Re: 58 Elm Park, Ferring

Further to the application which was recently submitted for loft extension/conversion and rear extension at the above I am writing to advise that there have been a couple of changes to the scheme which are summarised as follows:

Dwg. No. 08 / 078 / 6c
Drawn by David Bennett March 2009

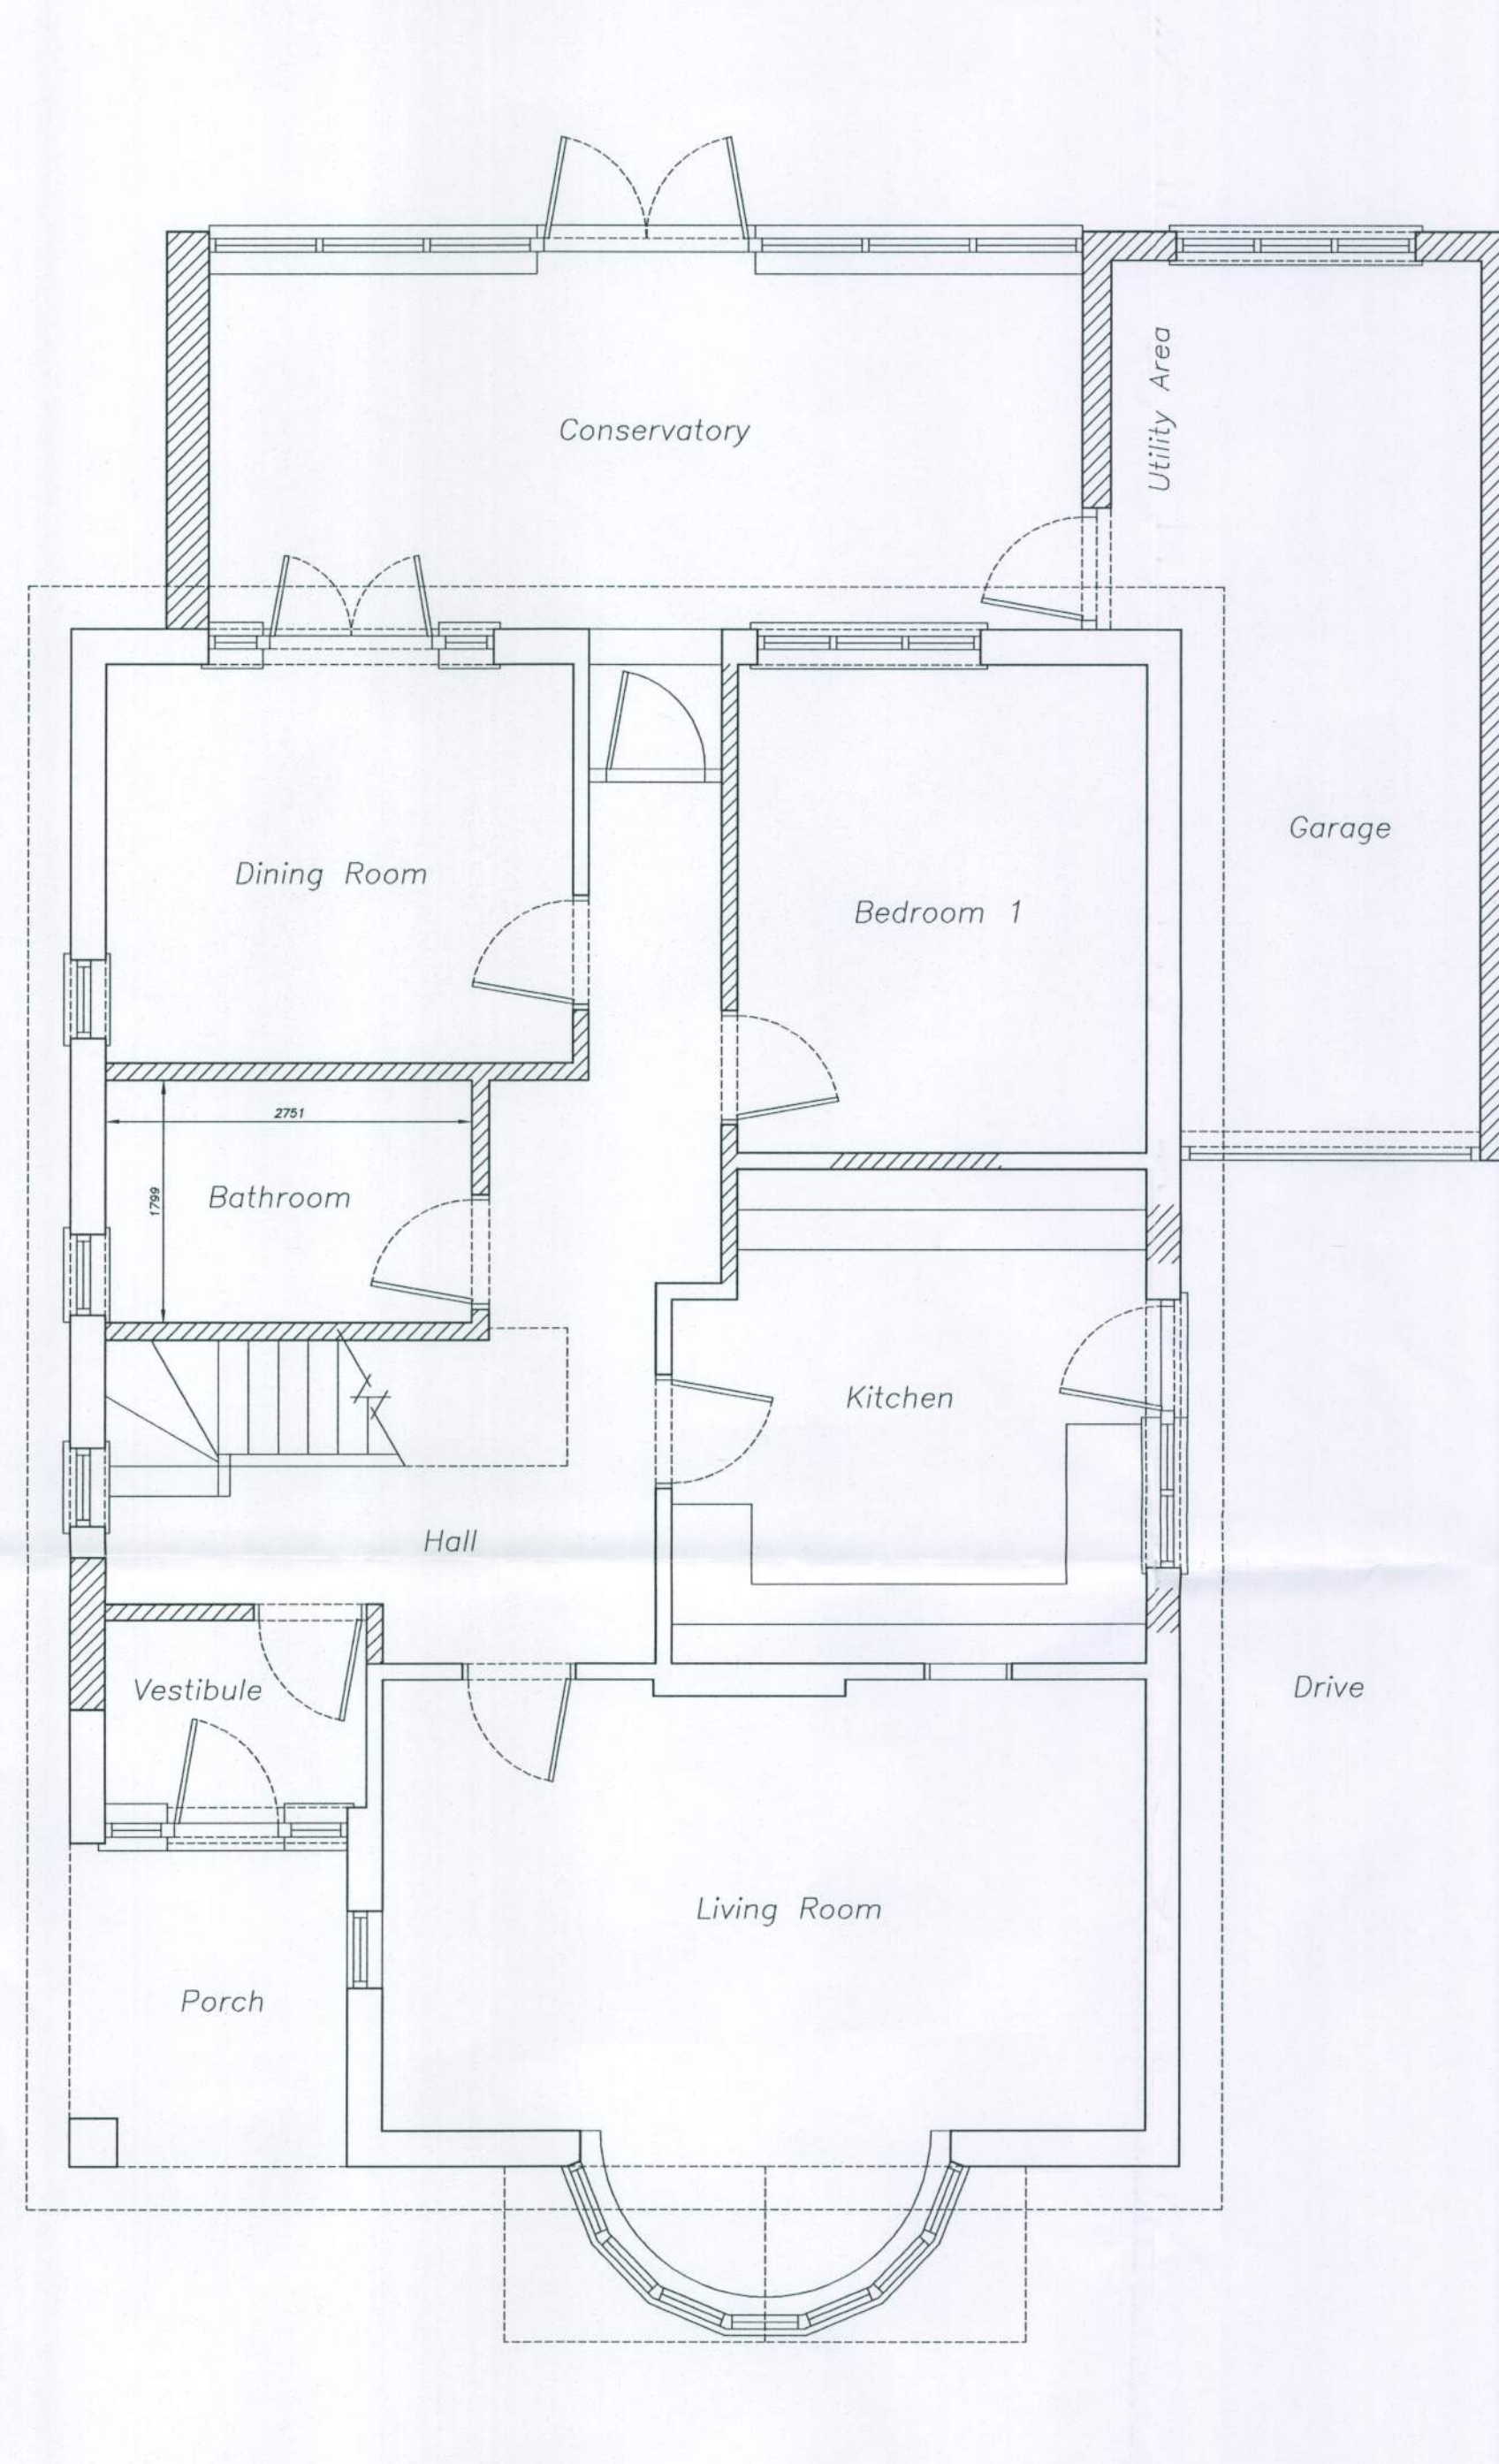
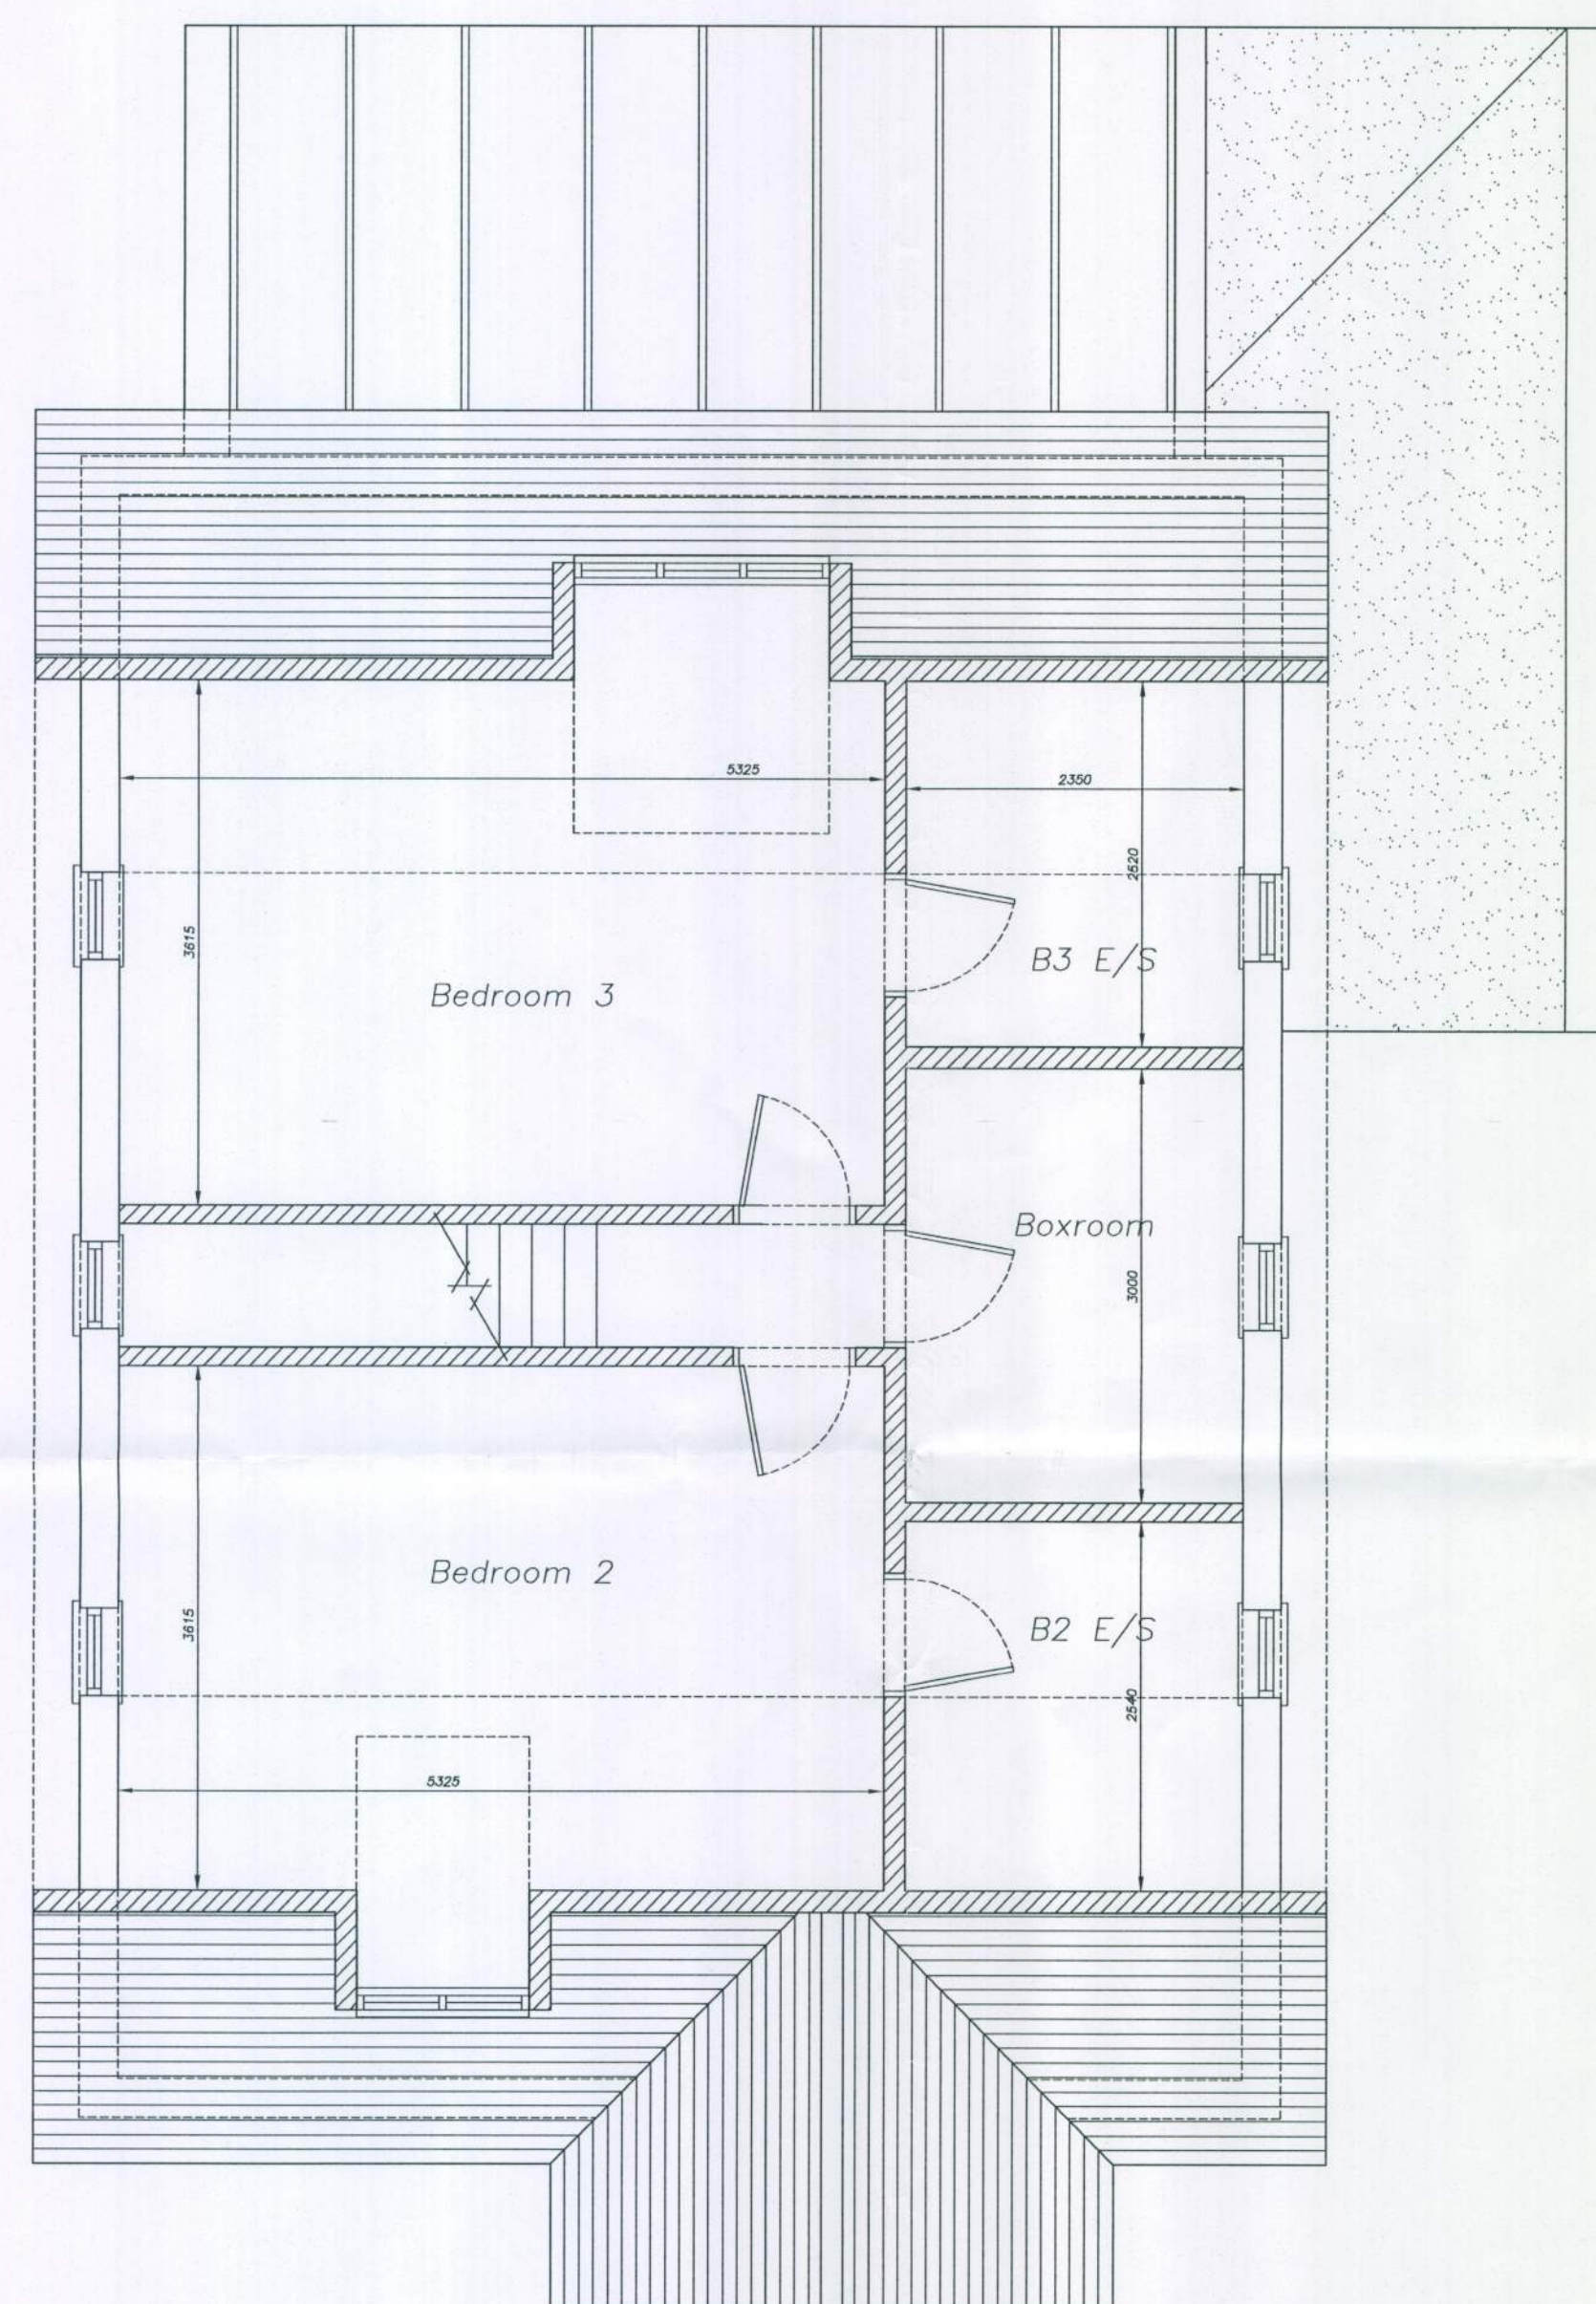
1. The rear dormer has been increased in width from a double casement window to a triple casement window.
2. The north and south gables are now both shown clad with weatherboard.
3. The western bedroom wall has been moved to the east to increase the size of the bedroom.
